H2Teesside Project

Document Reference: 9.7: Statement of Common Ground between H2 Teesside Limited and Natural England

Date: November 2024

**Statement of Common Ground between the H2 Teesside Limited and
Natural England**

FIGURE NUMBER
Figure 10-19a

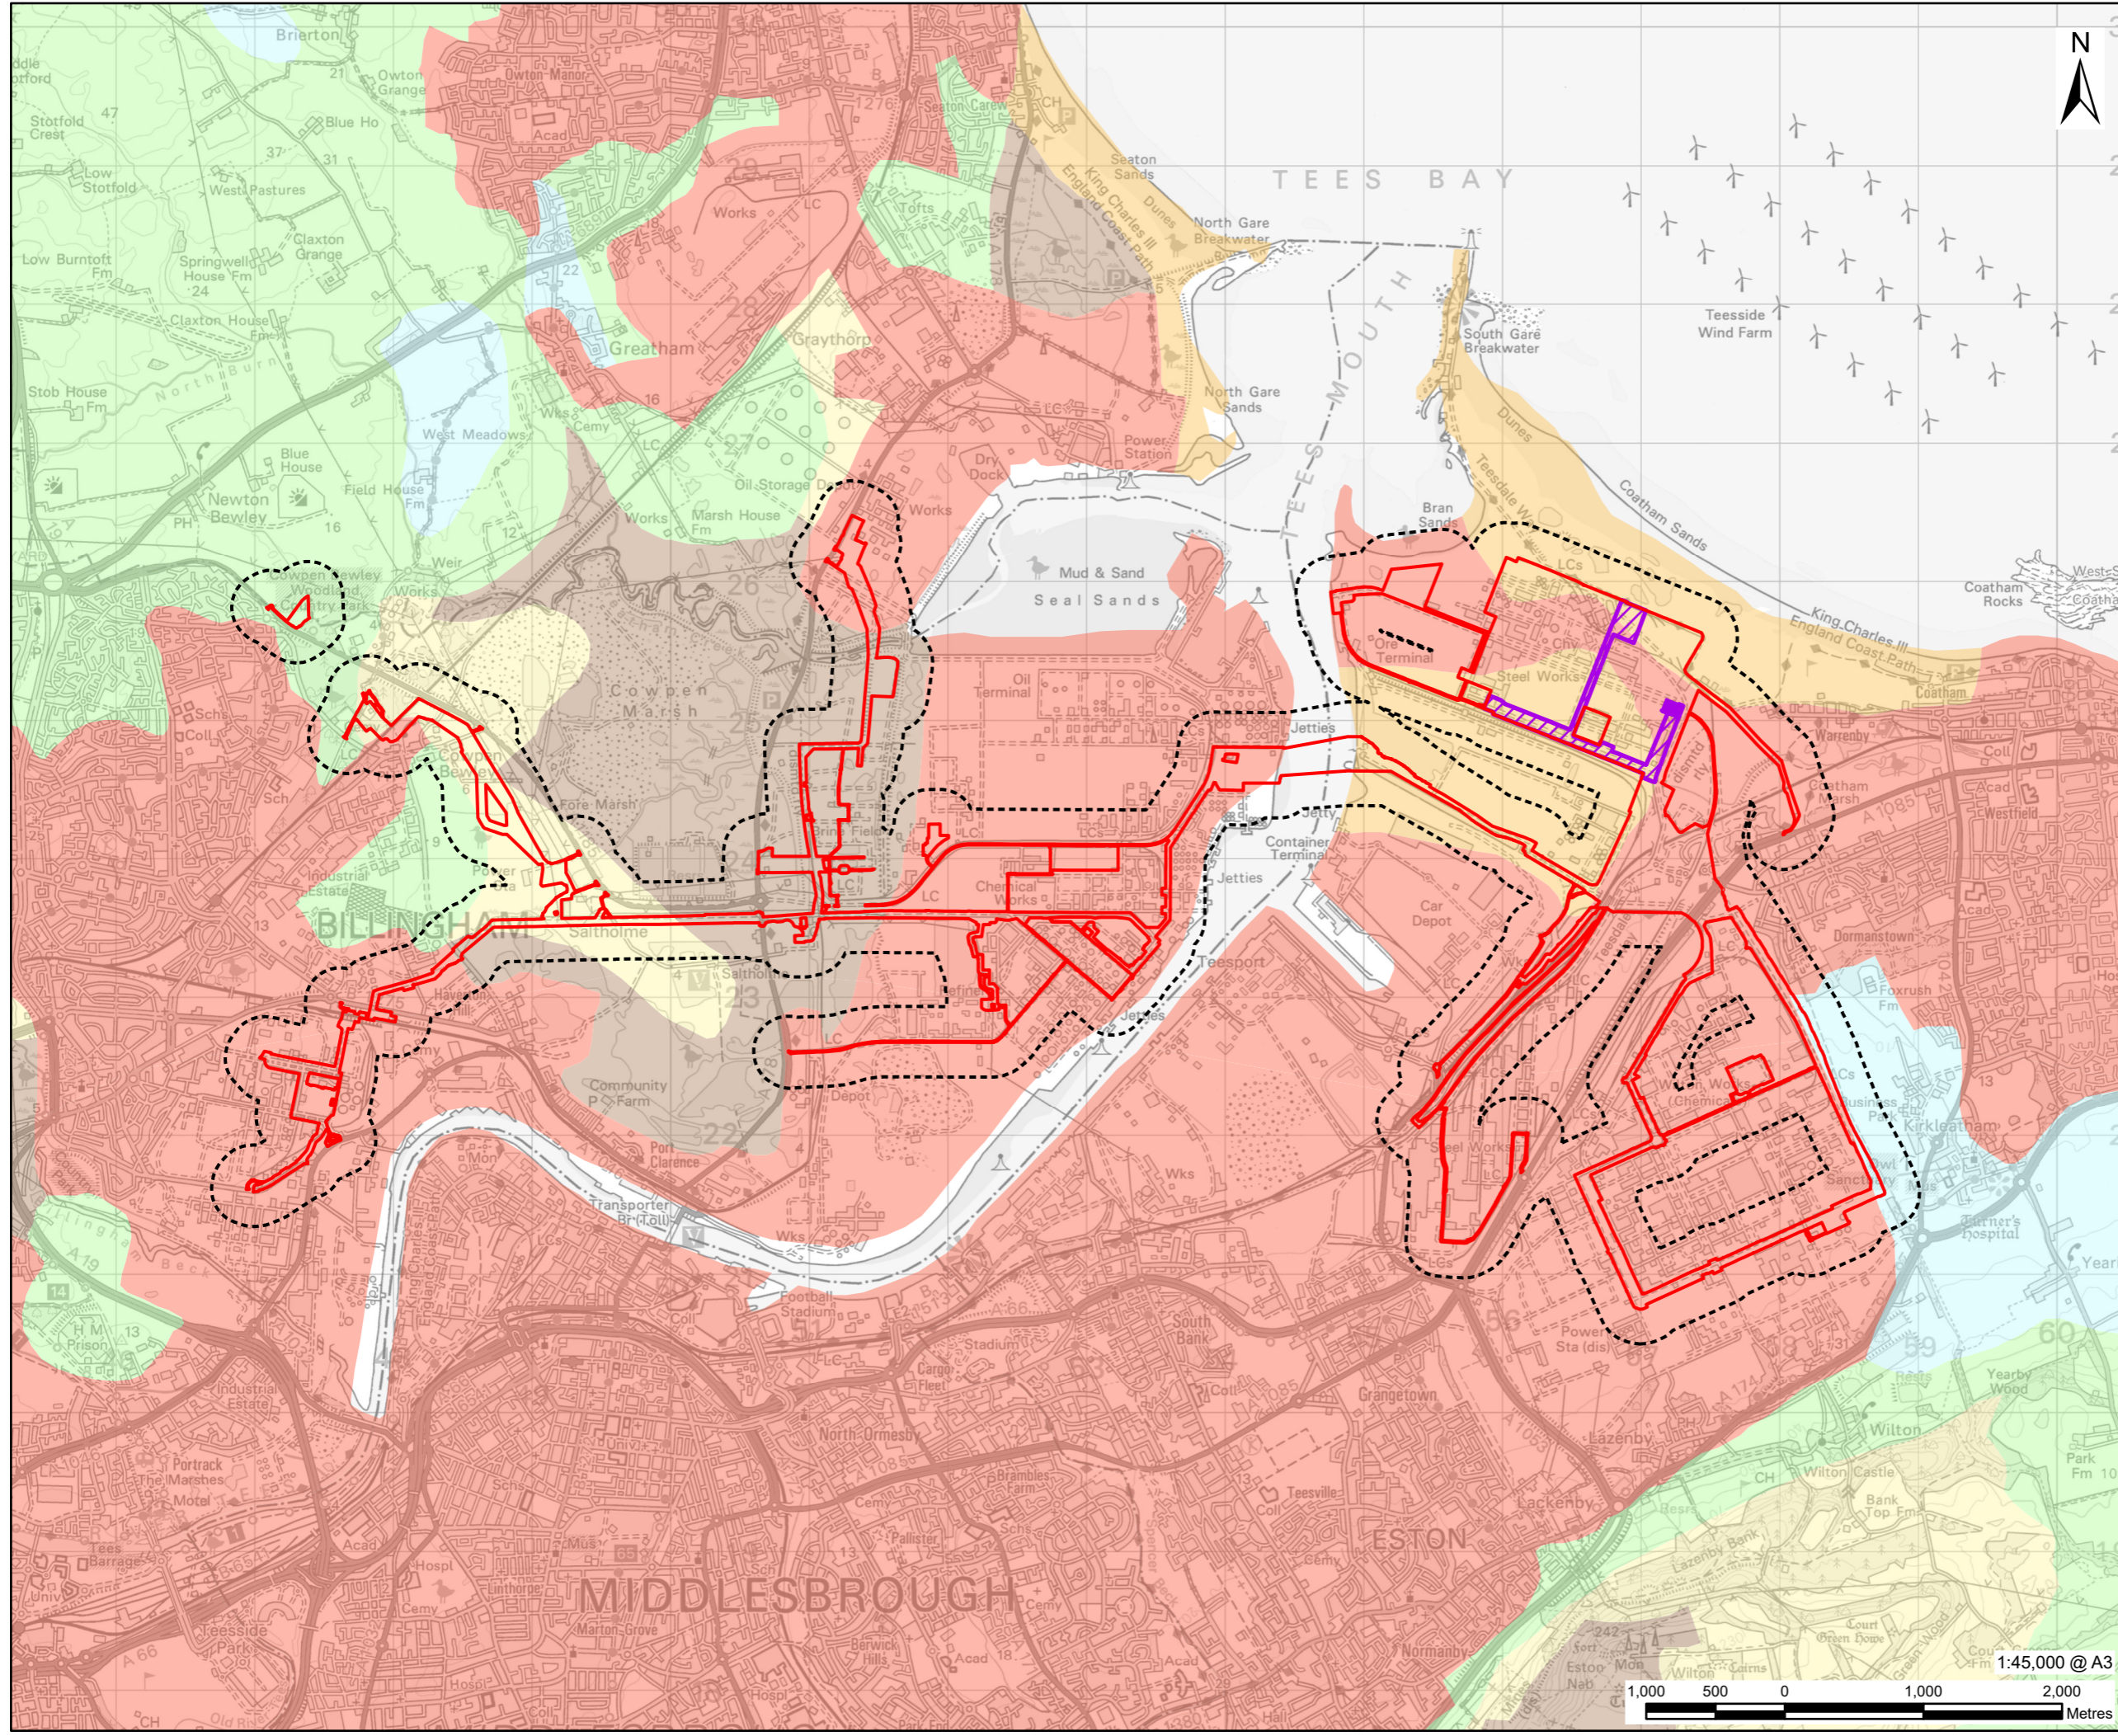
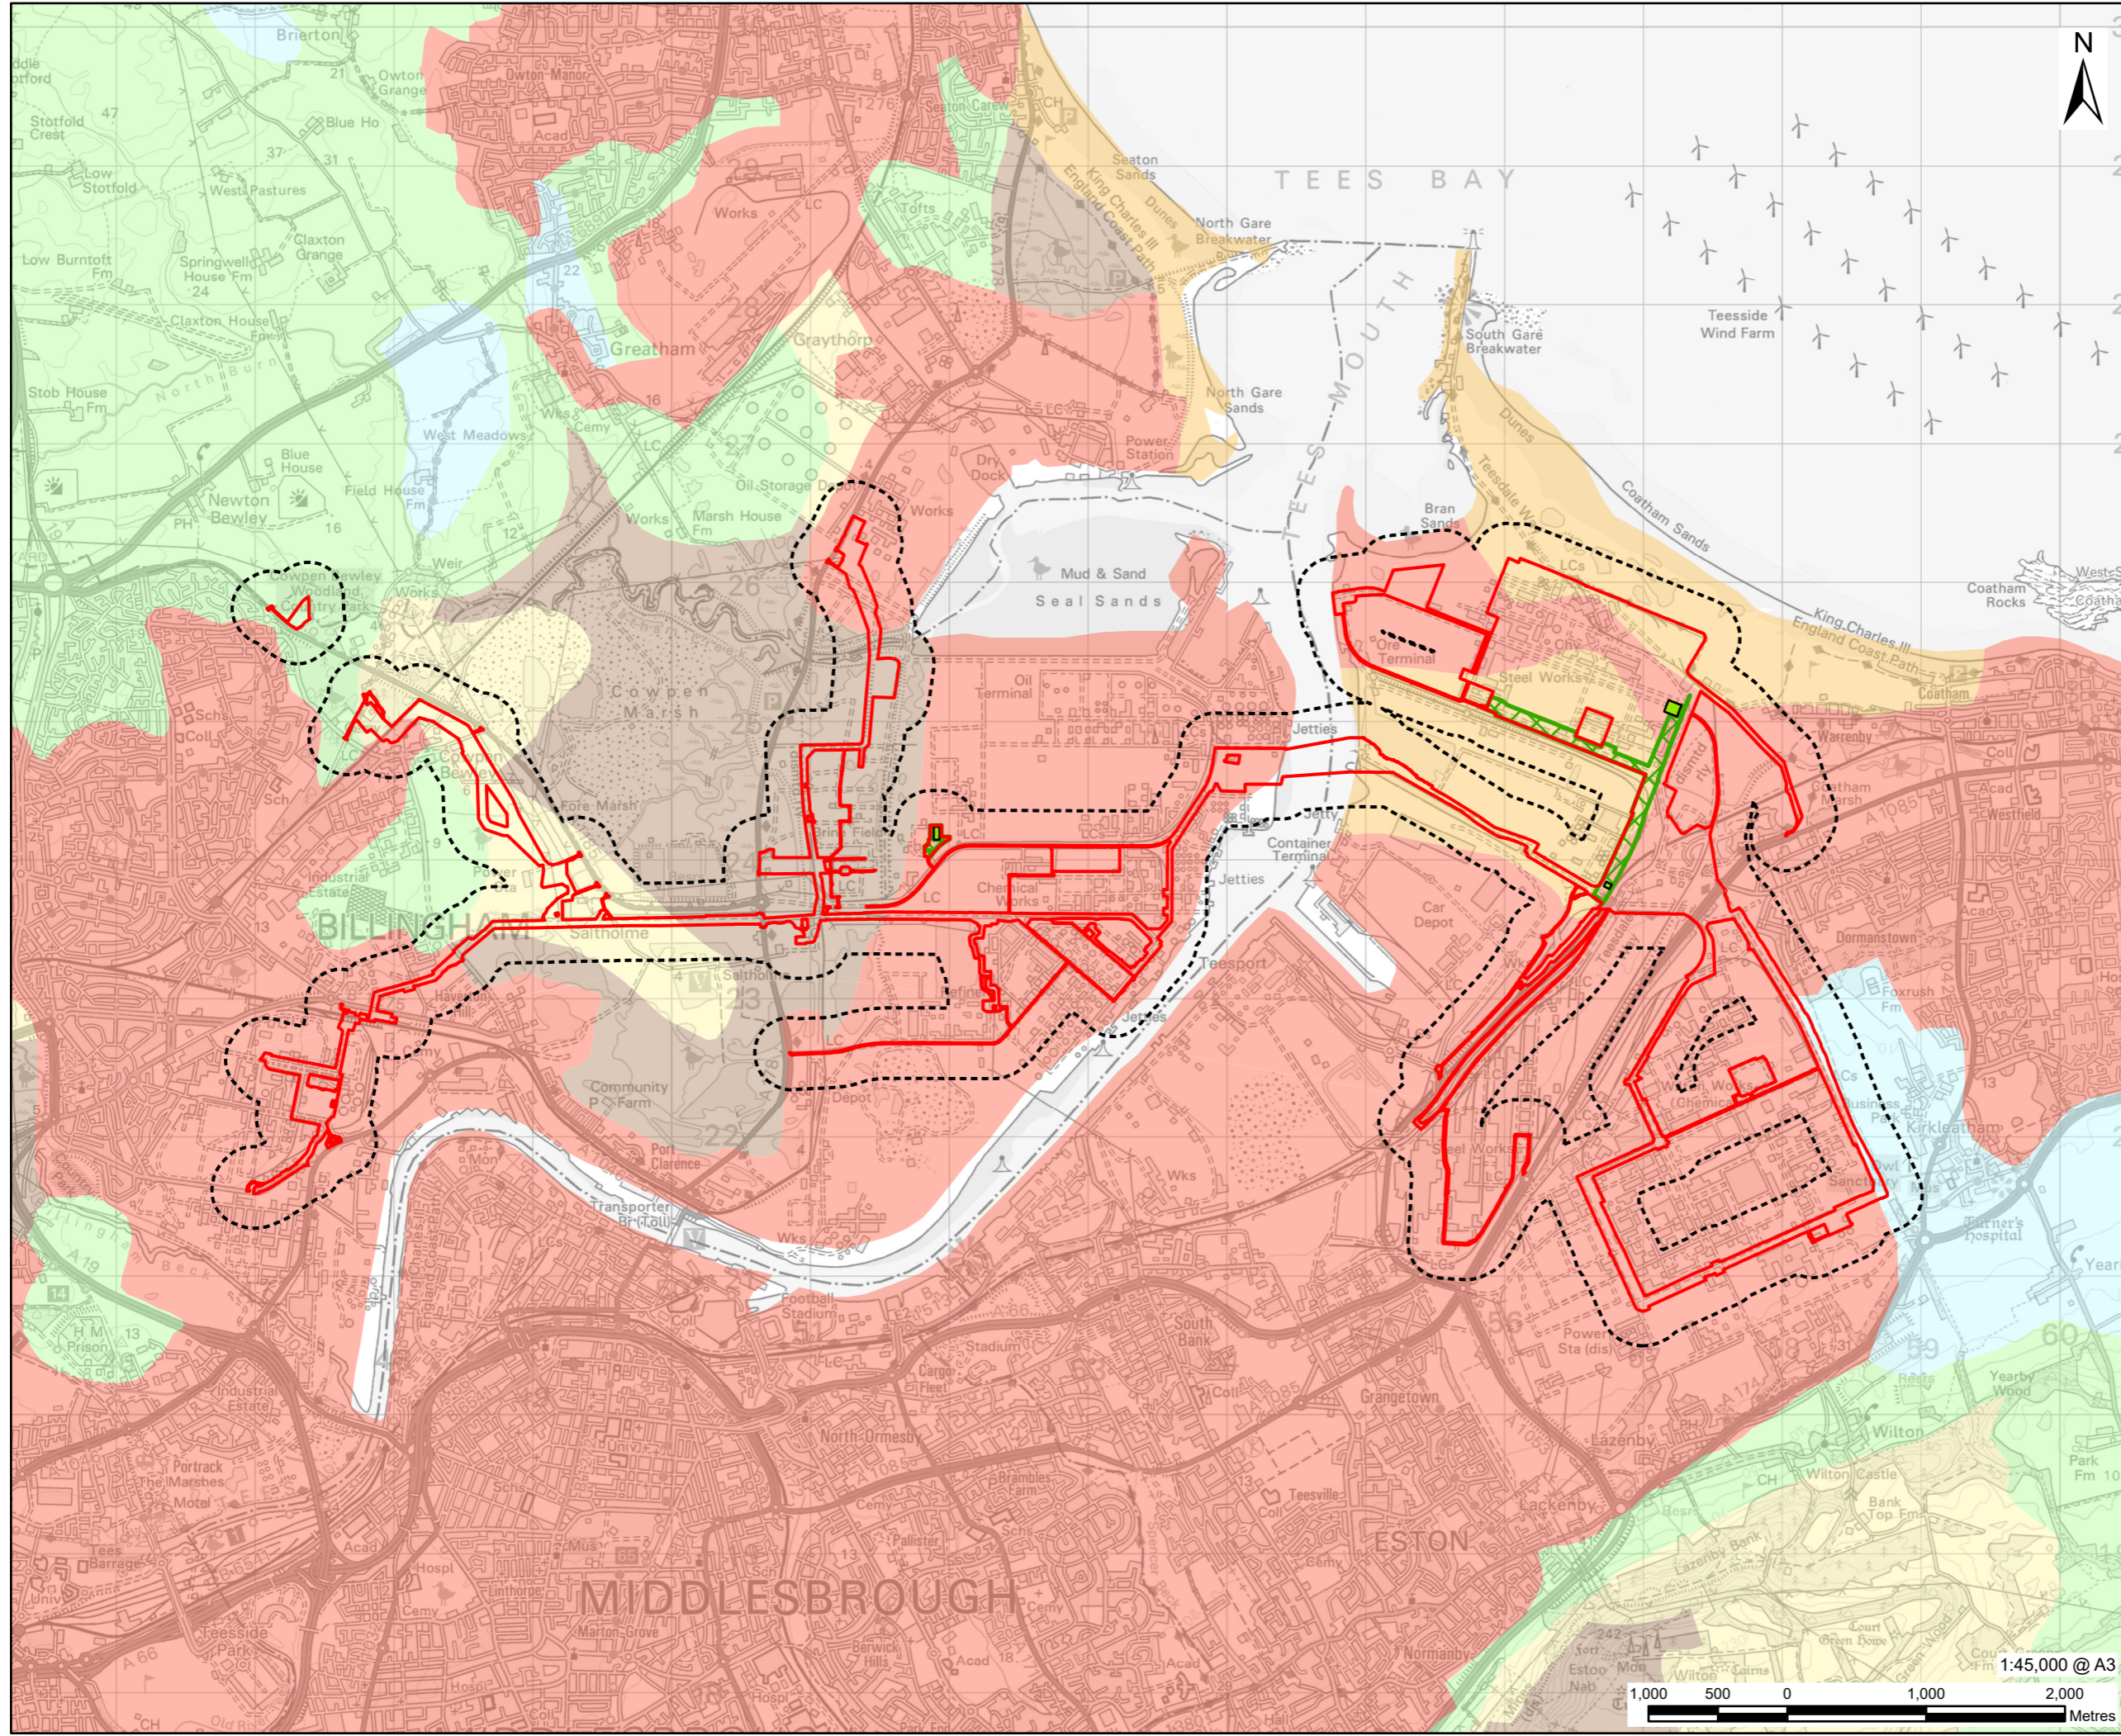
11.	Best and Most Versatile Land	NE35	<p>BMV land across the Proposed Development Site is limited, with the majority of the Main Site and Connection Corridors classified as Urban and Non-</p>	<p>NE considers appropriate mitigation to prevent the loss of BMV land, should be set out within the assessment. This would require a detailed</p>

SOCG ID	MATTER	REPRESENTATION REFERENCES	APPLICANT POSITION	NATURAL ENGLAND POSITION
			<p>Agricultural. A small portion of the Hydrogen Pipeline Corridor north of the River Tees has land classified as Grade 3, 4 and 5. As a worst case scenario Grade 3 land, at the Cowpen Bewley Replacement Land, is assumed to be Grade 3a, making it BMV land for the purposes of the assessment presented in ES Chapter 10 ‘Geology, Hydrogeology and Contaminated Land’ [APP-062].</p> <p>Taking into account the above, the Applicant does not propose to undertake supplementary ALC surveys of the Proposed Development Site at this time. However, the Applicant recognises the need for careful soil management and handling. The Framework CEMP [APP-043] will be amended to include the production of a Soils Management Plan (‘SMP’), included as part of the Final CEMP, produced prior to construction.</p> <p>ES Figure 10-1 [APP-110] is for artificial geology/made ground only. ES Figure 10-19 [APP-137] will be updated to include the correct colours for each ALC grade at Deadline 2.</p>	<p>ALC survey of the pipeline routes to inform restoration. The following actions should be undertaken:</p> <ul style="list-style-type: none"> • For all areas in which POST-1988 ALC Survey information is not available, an ALC survey should be undertaken. • The colours used for mapping should be updated to match standard ALC colours. • The soil information presented (Figure 10-1 [APP-110]), should include the mapped soil associations. • The consideration of soil handling should be expanded in a Soils Management Plan (SMP). <p>D4 update: Natural England welcomes the updated Figure 10-19, submitted into the Examination at Deadline 2 and the commitment to preparing a Soil Management Plan in the Framework CEMP, submitted into the Examination at Deadline 2.</p> <p>Natural England advises a detailed ALC survey for the full Study Area should be conducted by</p>

SOCG ID	MATTER	REPRESENTATION REFERENCES	APPLICANT POSITION	NATURAL ENGLAND POSITION
			<p>No further updates are anticipated to be submitted.</p> <p>D4 update: The Applicant will continue to discuss this matter with Natural England through the SoCG between the two parties.</p>	<p>the Applicant, in which post-1988 ALC survey information is not available.</p>
12	DCO Requirements	n/a	<p>The Applicant is continuing discussions with Natural England regarding matters raised in their Relevant Representation and by extension the specific wording of Requirements in the draft DCO.</p>	<p>The drafting of DCO Requirements 4, 14, 15 and 20 remain under discussion as discussion continues around Natural England’s Relevant Representation.</p> <p>Natural England is continuing discussions with the Applicant on matters pertaining to the draft DCO.</p>
